**RE: 7121 Washington
Grading and Drainage Plan
Engineer's Stamp Date 10-24-2016 (File:D17D016)**

Based upon the information provided in your submittal received 10-24-2016, the above-referenced revised plan is approved for Building Permit with the following conditions:

Re: 7121 Washington (Harroun)
7121 Washington Ave. NE
Traffic Circulation Layout
Architect's Stamp 11-21-16 (D17-D016)

Based upon the information provided in your submittal received 11-21-16, the above referenced plan cannot be approved for Building Permit until the following comments are addressed:

A5 TRAFFIC CIRCULATION LAYOUT
1" = 20'-0"

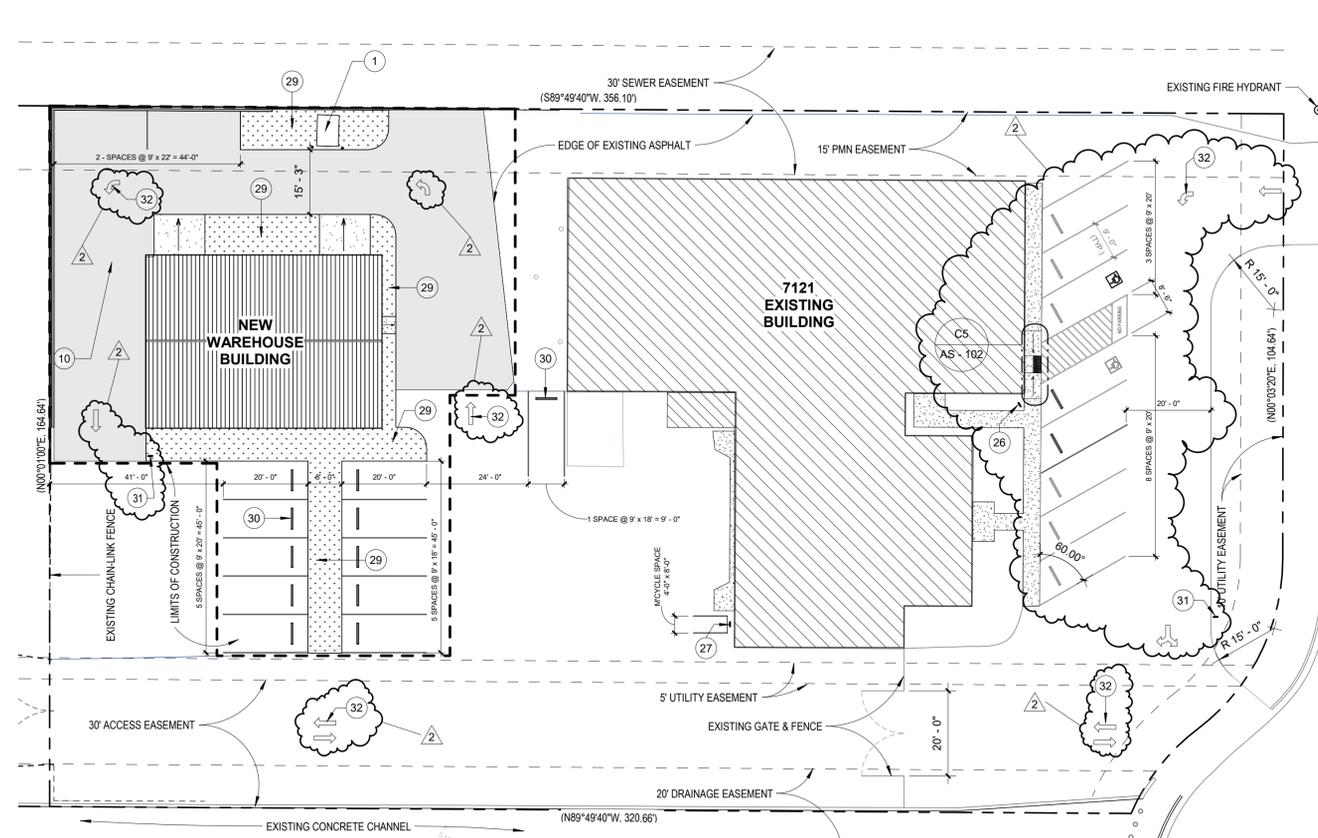
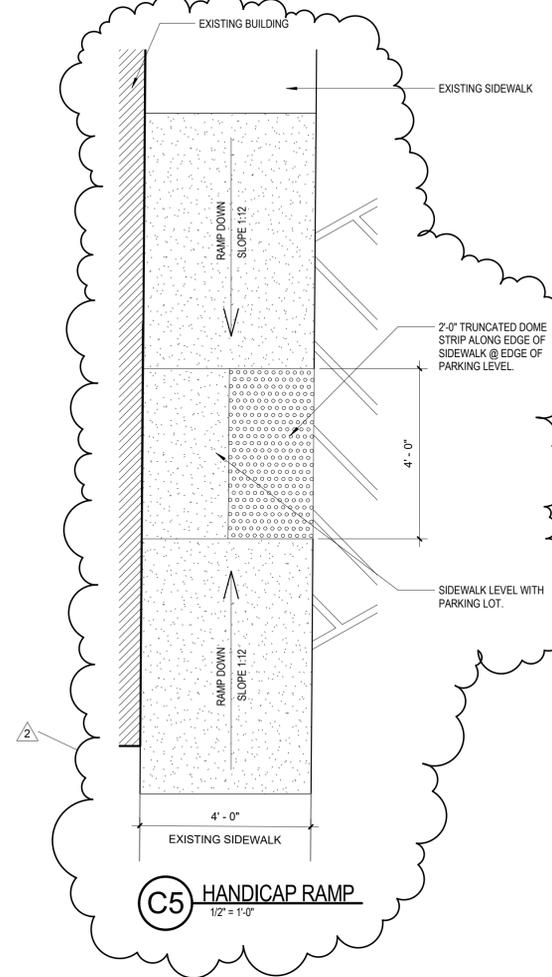
1. The first flush pond is designed with a berm, but it is not clear if a spillway is necessary. Please assess if one should be designed, and if needed, it can be included in the as-built.
2. The above-mentioned berm will need to be protected from erosion, to prevent sediment transport to the offsite pond.
3. Consider adding curbing or edge protection for the pond to prevent erosion at the edge of asphalt, and/or designing an inlet point with erosion control.

1. Please identify and dimension existing sidewalk, drive pads, and handicap access ramp and anything that influences the parking and circulation on the site.
2. Please dimension the width between the parking stall and existing fence.
3. Identify if the parking at the existing building will be restriped or is existing. The handicap ramp should be located on the sidewalk and not in the handicap access aisle.
4. All one-way vehicular paths require pavement directional markings and a posted **"Do Not Enter"** sign at the point of egress. Please show detail and location of posted signs.
5. List radii for all curves shown; for passenger vehicles, the minimum end island radius for passenger vehicles is 15 ft. Radius for delivery trucks, fire trucks, etc. is 25 ft. or larger.
6. Please contact me @ 505-924-3630 to discuss TCL before submitting.
